Responses to flora issues raised by the Department of Planning, Parramatta City Council, the Department of Environment and Climate Change

Department of Planning, Parramatta City Council and the Department of Environment and Climate Change have requested further flora related information on the following issues for MP 08_0258 – Early Works Package at 61 Mobbs Lane, Epping. The requested additional information is provided below.

Department of Planning – MP 08 0258 – Early Works Package

Child Care Facility and Detention Lake

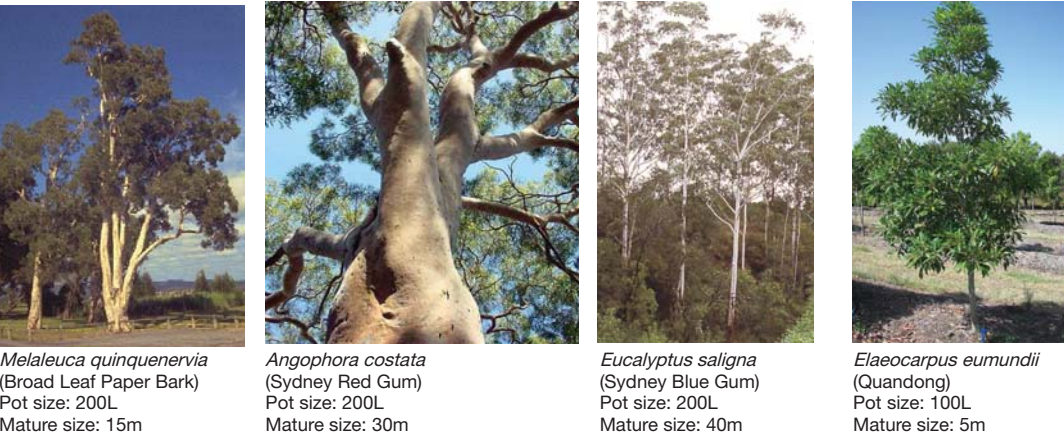
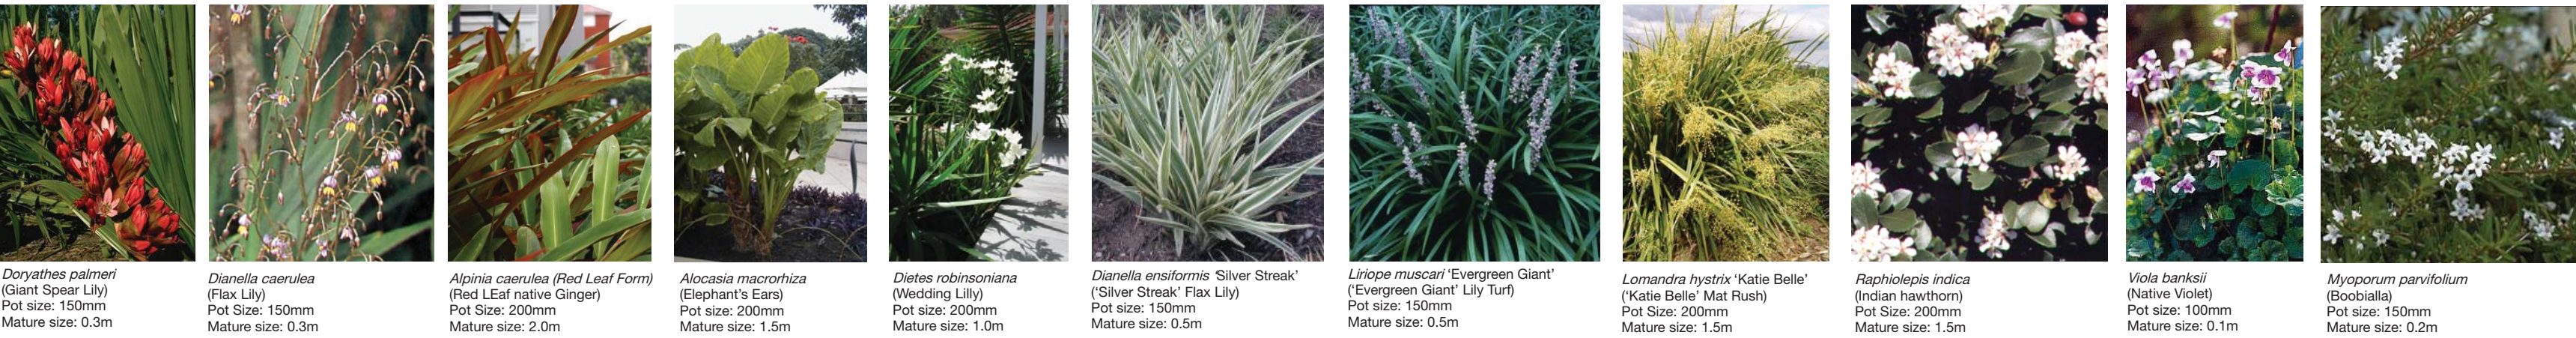
- *The childcare centre playground is an inappropriately located next to the proposed detention basin with potential health conflicts created by such impacts as mosquito population / odour etc.*

- *If the pond is retained in the current position it will need to be fenced particularly given its location near an unfenced children's playground.*

Meriton has addressed this issue in the submitted Preferred Project Report.

Meriton has addressed this issue in the submitted Preferred Project Report.

Site Section A-A - Nature Play / Mobbs Lane Reserve interface

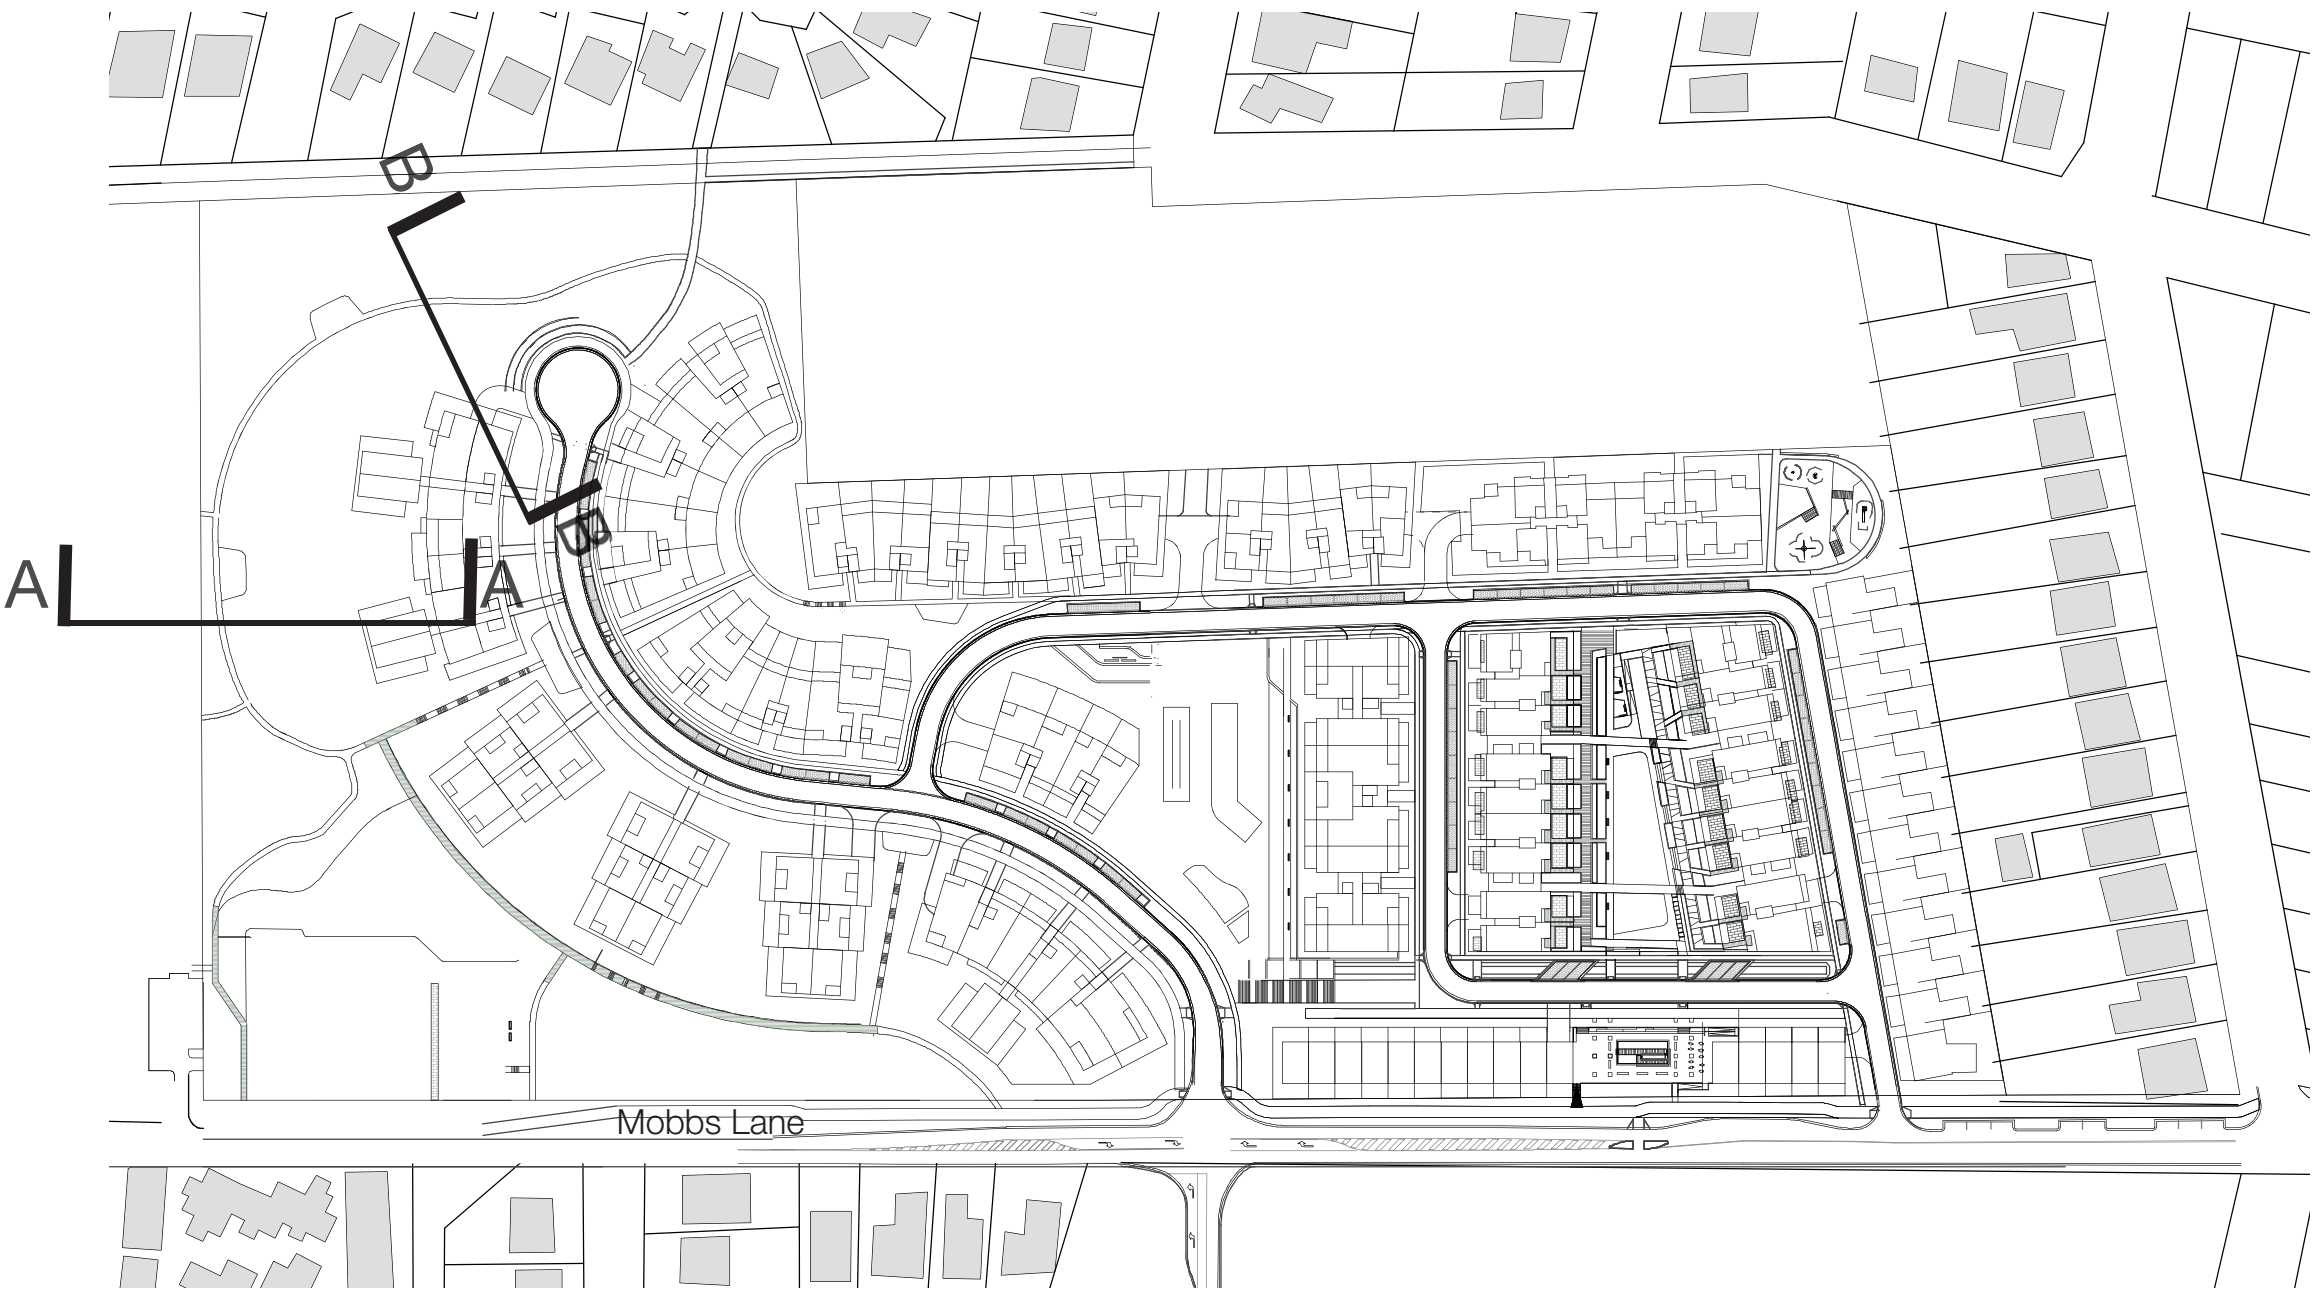
- *It is unclear as to how the boundary with Mobbs Lane Reserve will be defined. In consideration of aesthetics and wider public access, it would be more appropriate to define with bollards to visually integrate as one open public space areas.*

Meriton has addressed this issue in the submitted Preferred Project Report.
